# Rezoning Transportation Analysis

Petition Number: 2023-030

**E1From:** Jake Carpenter, PE  
Jacob.carpenter@charlottenc.gov  
980-221-5675

Date	Description
5-24-23	First Review (DR)
6-21-23	Second Review (DR)
07-28-23	Third Review (TM)
08-29-23	Fourth Review (TM)

RZ-1.0

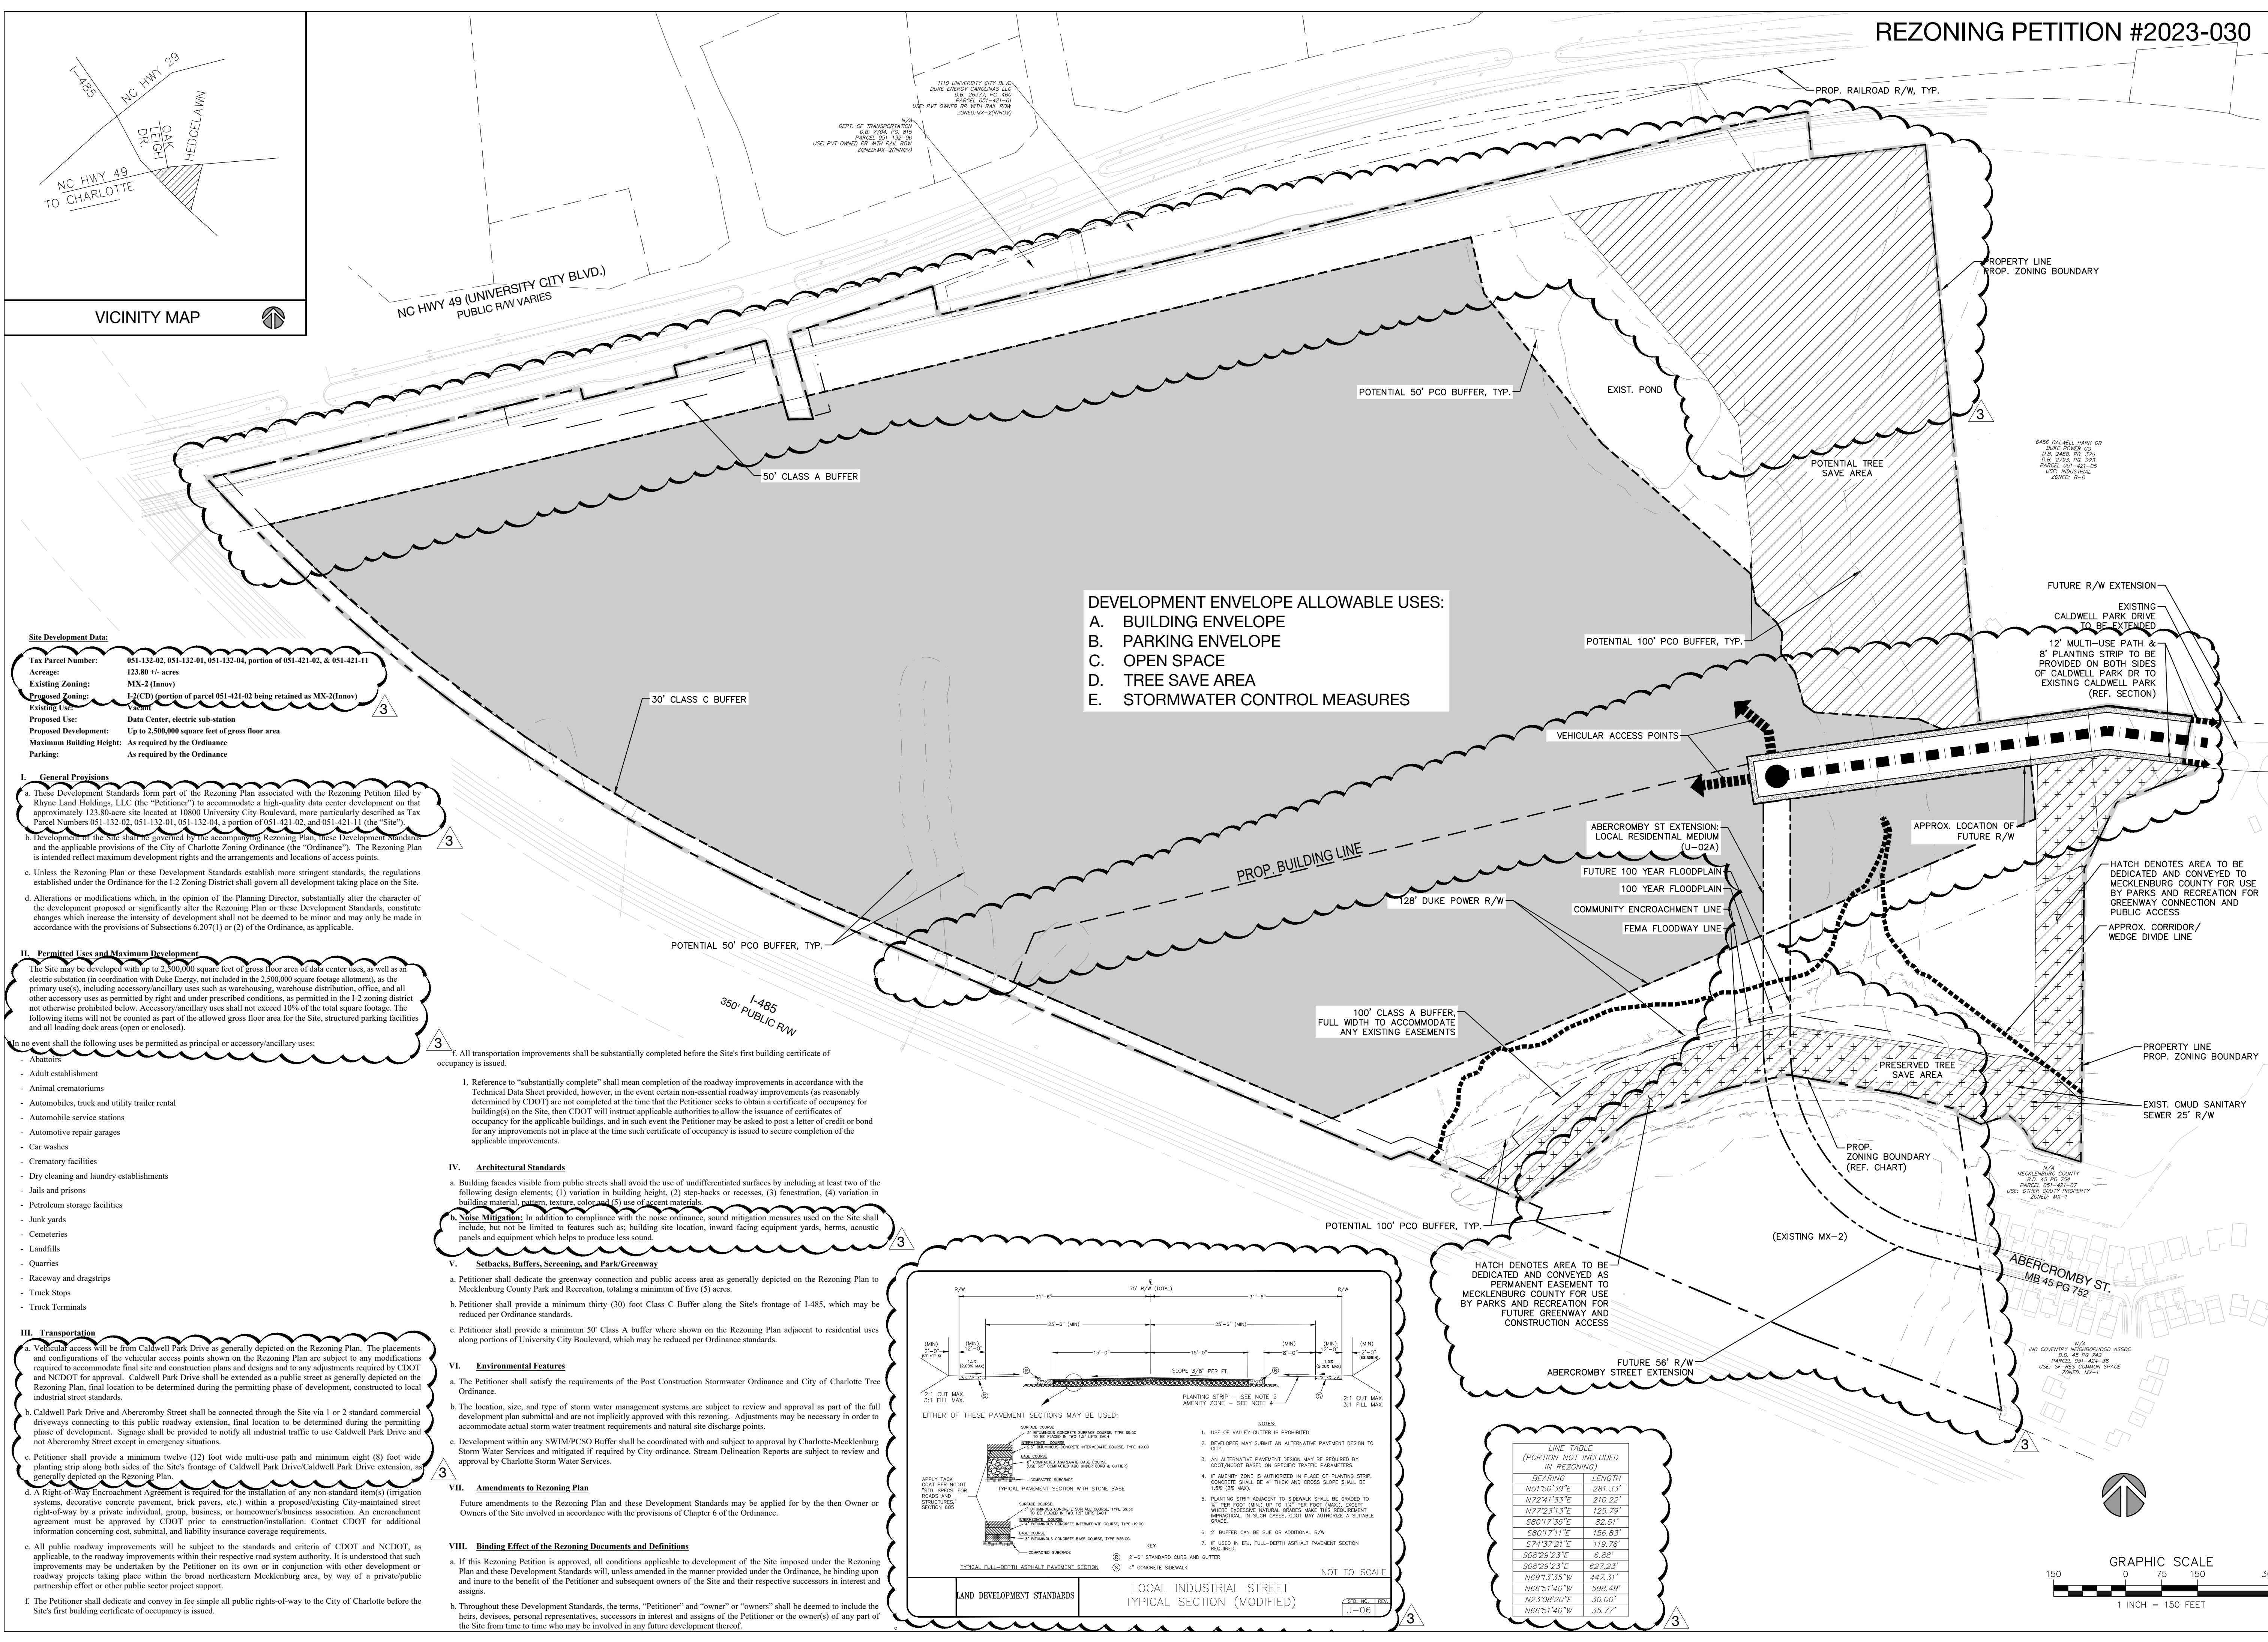
### 2. ~~NEW COMMENT 07.28.2023:~~ Revise site plan and conditional notes to connect Abercromby Street to Caldwell Park Drive. Site access shall be via 1 or 2 standard commercial driveways connecting to this roadway extension. Site plan shall commit to installing signage for all industrial traffic to use Caldwell Park Drive and not Abercromby Street.

~~**Clarifying Comment 7.28.2023:** 12-foot multi-use path shall be placed on both sides of the Caldwell Park Drive extension.~~
